# SITE PLAN

14150 Herring Rd  
Colorado Springs, CO 80908  
Parcel ID: 5205101010  
Lot area: 14.66 Acres  
Paper Size: 11"x17"  
Legal Description: Lot 6  
Wildwood Ranch Estates Fil 2  
Plat: 2453  
Zone: RR-5

File Number:  
PPR249

SITE PLAN
 14150 Herring Rd
 Colorado Springs, CO 80908
 Parcel ID: 5205101010
 Lot area: 14.66 Acres
 Paper Size: 11"x17"
 Legal Description: Lot 6
 Wildwood Ranch Estates Fil 2
 Plat: 2453
 Zone: RR-5
 PPR249

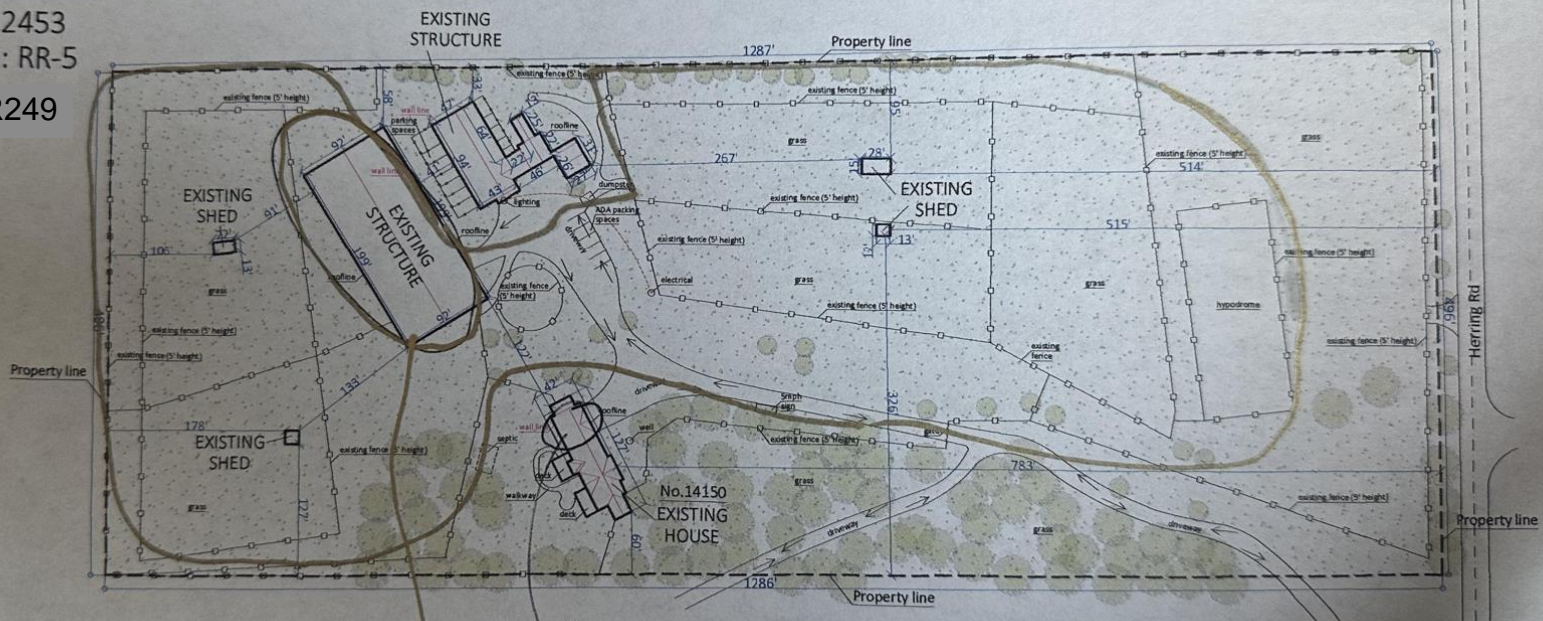
Please add:  
-name of applicant  
-lot size (14.66 acres)  
-total gross building sq footage (all of the buildings sq footage added up)  
-lot area coverage %  
-open space and impermeable space %

Provide a note stating:  
"Per the County GIS, Floodplain X was found at  
the property, and there are no floodplain  
concerns"

Include date  
associated with  
when revisions

Provide height of  
fencing

Label as "parking  
Spaces"  
-include ADA spot

Please depict:  
traffic circulation in and off the  
property

please label fences and driveway as existing, or  
provide a general note clarifying that what is  
shown is all existing. If there are any proposed  
improvements please clearly identify.
